Your Ref
Y/10/19/PL
Our Ref
PLAN-026884
Date
14/03/2019

Proposal: Construction of single storey rear extension & replacement barrel store. Replacement of existing flat roof with pitched roof over single storey rear wing & associated works.
Site: The Maypole Inn, Maypole Lane, Yapton, BN18 0DP.
Y/10/19/PL

Luis Silva
Developer Services

project	The Maypole Inn Maypole Lane, Yaption West Sussex		
drawing	Site/Block Plan As Proposed

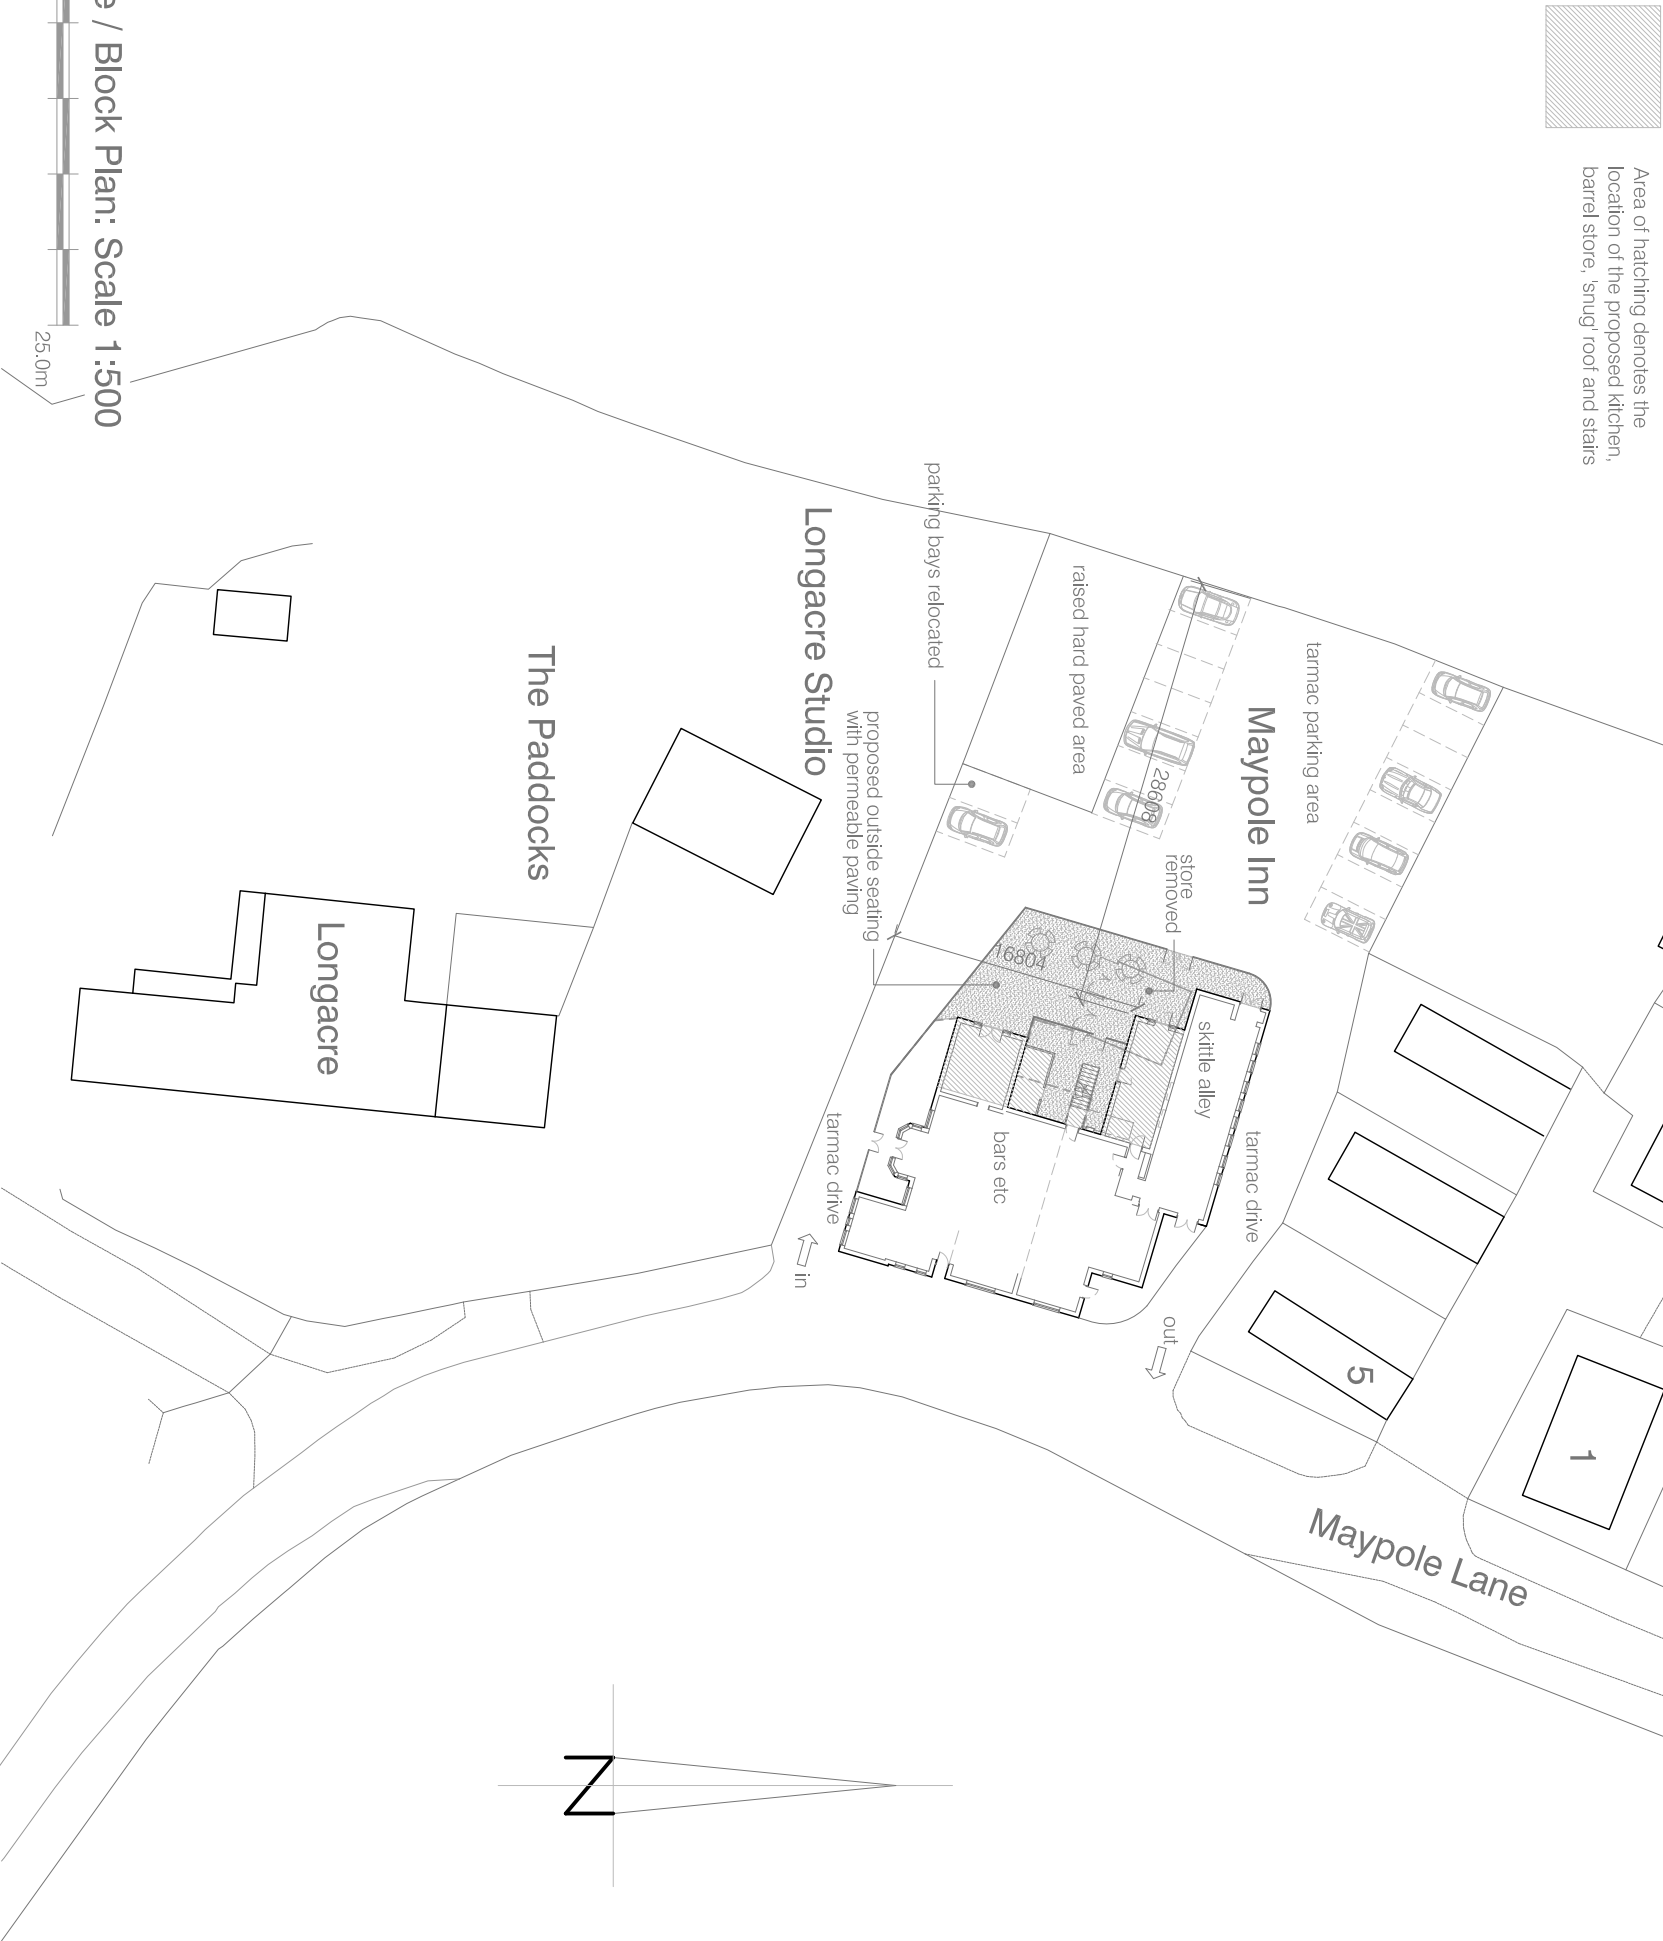
Please find attached a plan of the sewer records showing the approximate position of foul sewer within the site. The exact position of the foul sewers must be determined on site by the applicant before the layout of the proposed development is finalised.

- No development or new tree planting should be located within 3 metres either side of the external edge of the public sewer.
- No new soakaways should be located within 5m of a public sewer.
- All existing infrastructure should be protected during the course of construction works.

Indicative Kitchen Layout
As Proposed

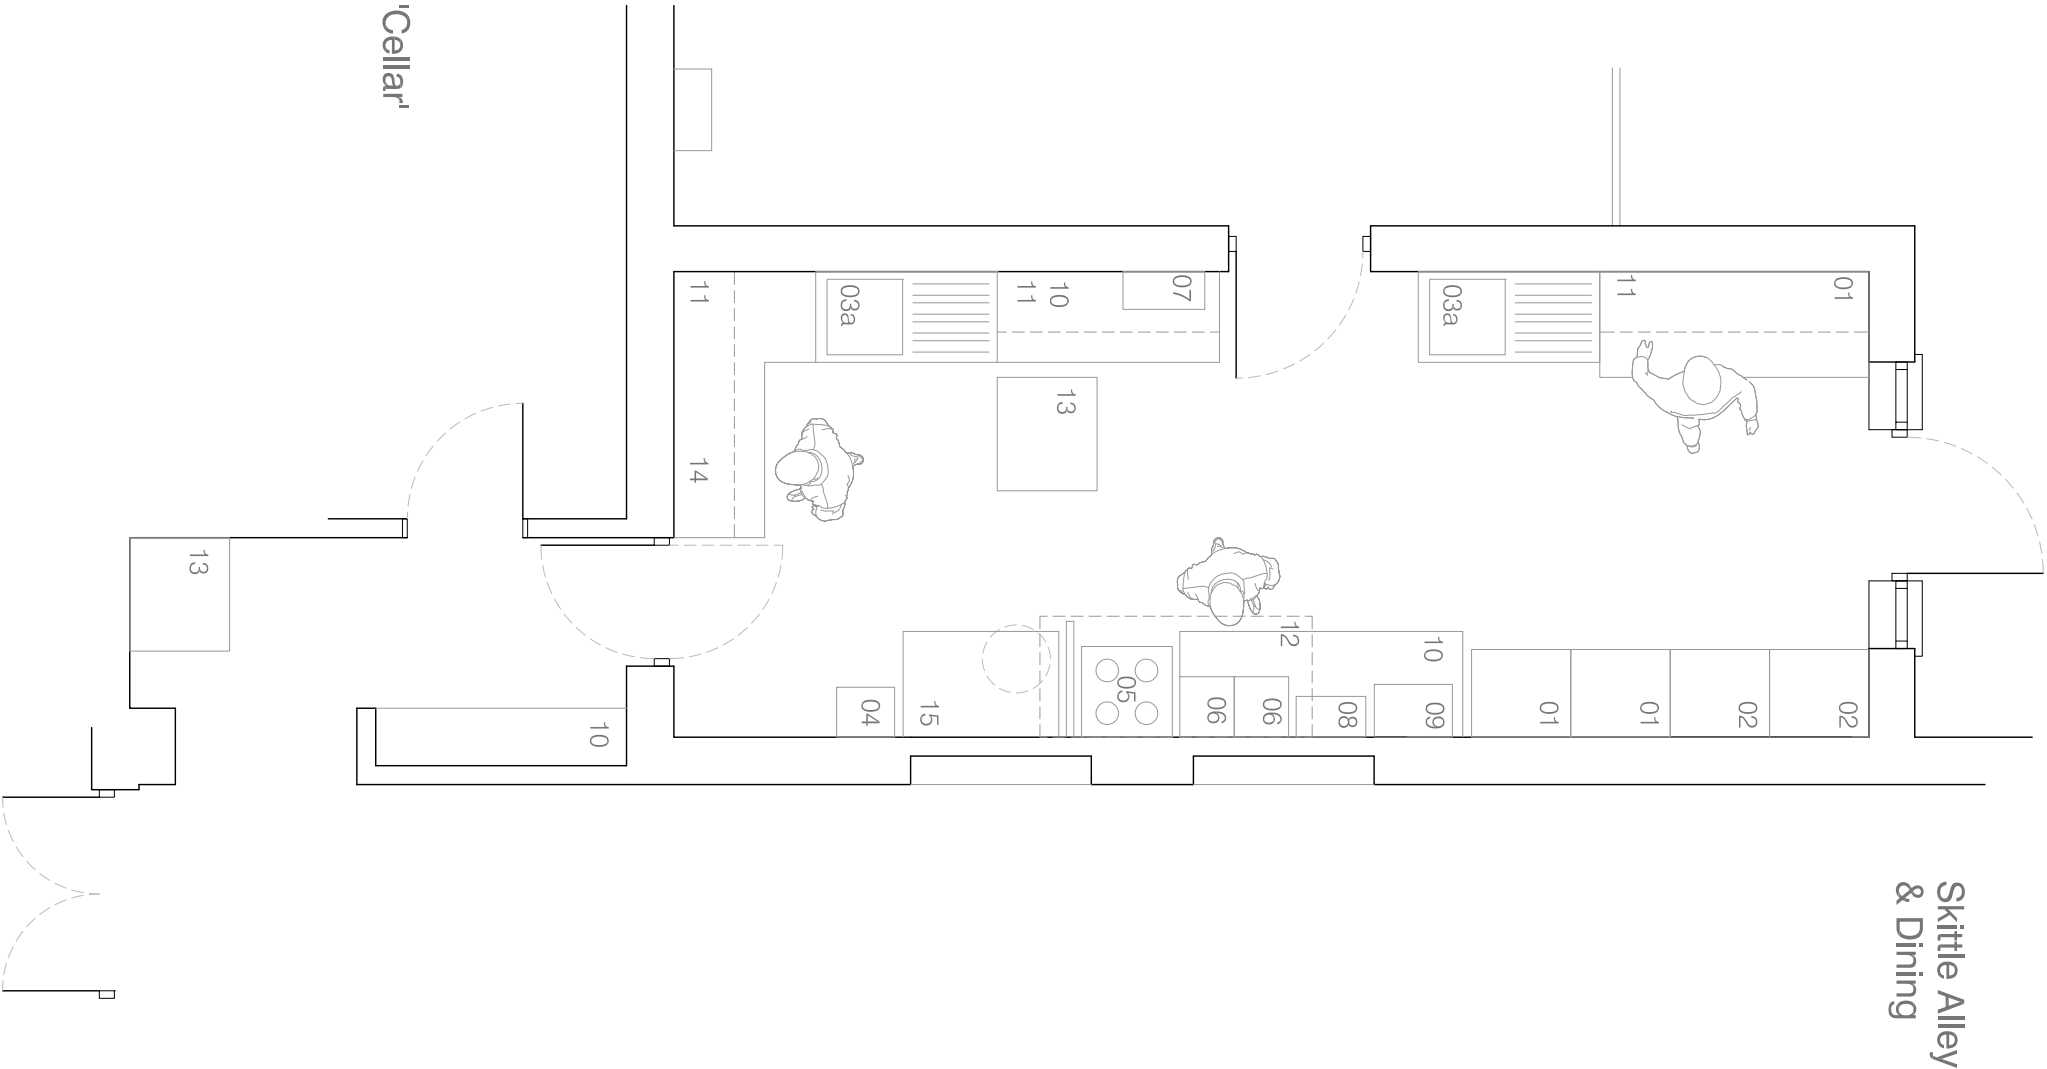
The applicant should be advised that a wastewater grease trap should be provided on the kitchen waste pipe or drain installed and maintained by the owner or operator of the premises.
